Planning Application: **OUTLINE** planning application for the demolition of existing structures on site and construction of 51 new dwellings on this site.

Reference: Y/5/17/OUT

Location: Cinders Nursery & Land R/o Cinders Lane, Yapton

Barrell Plan Ref: 16371-BT2

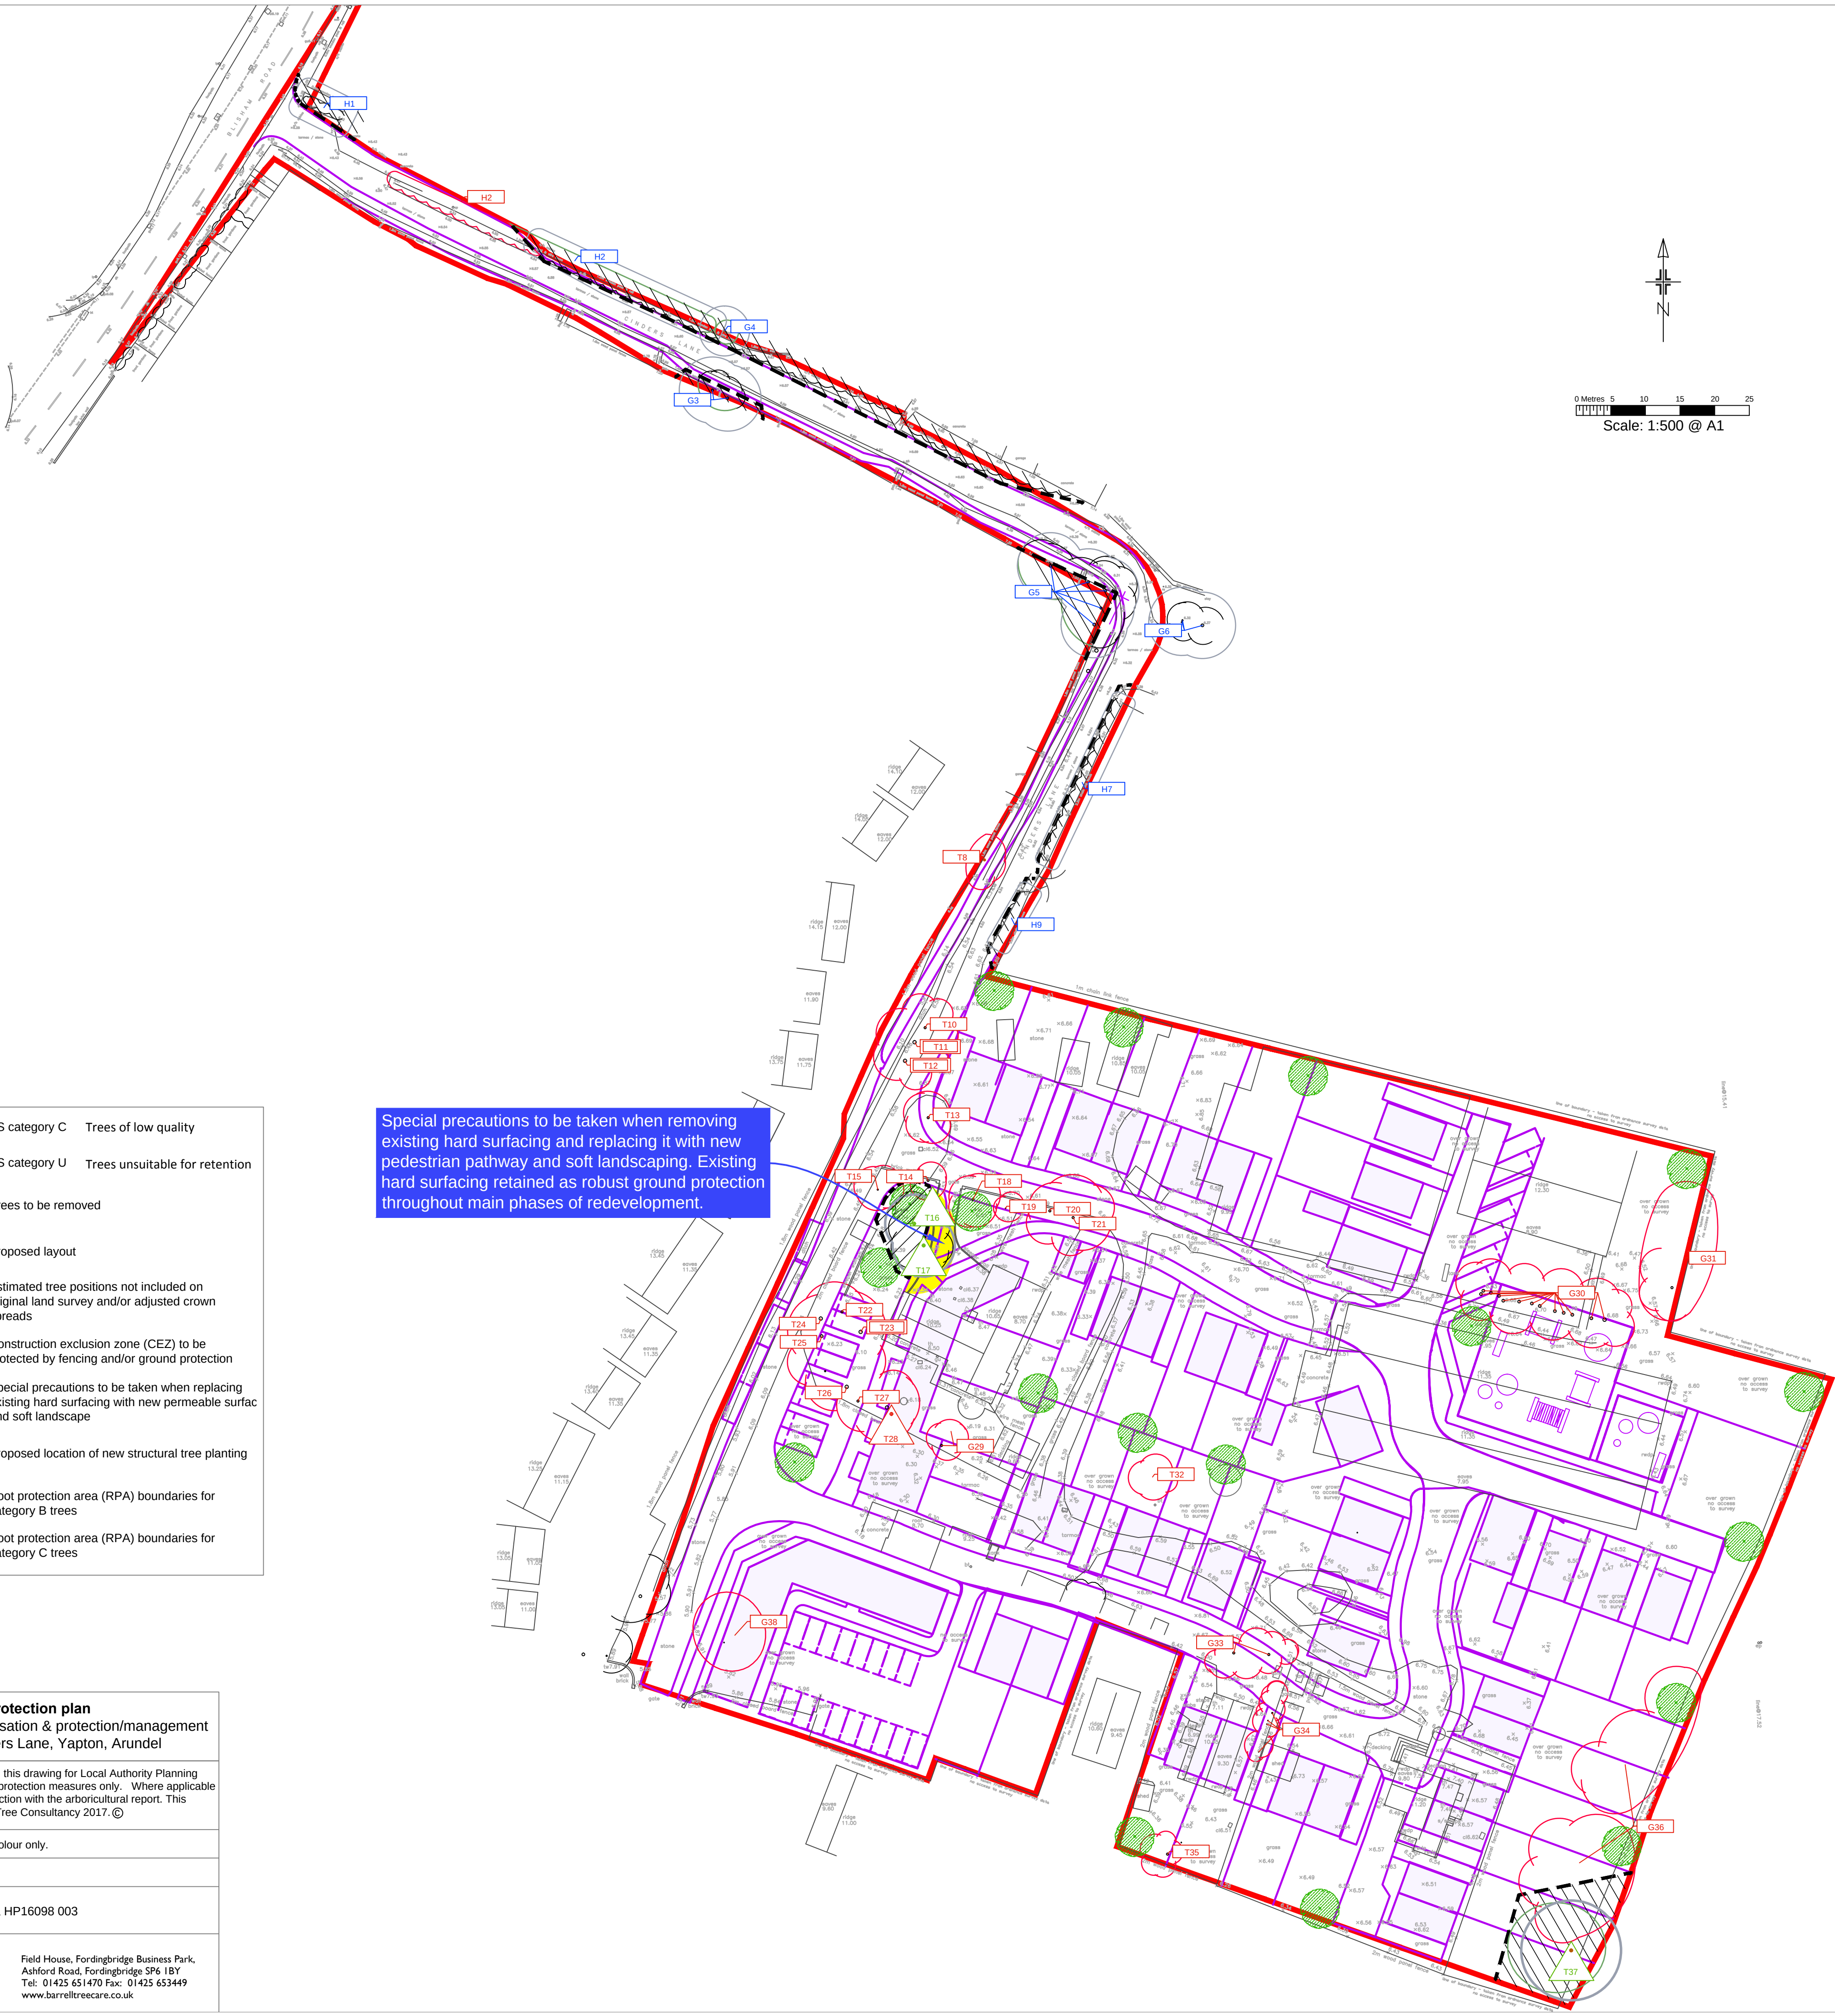
- Provided that this site is developed as outlined in the AMS report and shown on the Tree protection Plan then I would not have an issue on tree grounds.

1. All demolition & construction works are to be carried out in strict accordance with :-
Arboricultural Method Statement Report Ref: **Barrell Tree Consultancy – 16371-AA2-CA – 19 December 2016.**
and Tree Protection Plan ref: **Barrell Tree Consultancy – 16371-BT2 – 2017.**

- A **PRE-COMMENCEMENT Site Meeting** is to take place between the Arun DC Tree Officer and the Arboricultural Consultant representing the site owners – at this meeting all protective fencing will be inspected along with ground protection measures – they will be assessed to verify that they are 'Fit for Purpose' as required under British Standard 5837:2012 and have been erected and positioned exactly as shown on the **Tree Protection Plan Appendix A – Rev B. Feb2017.**
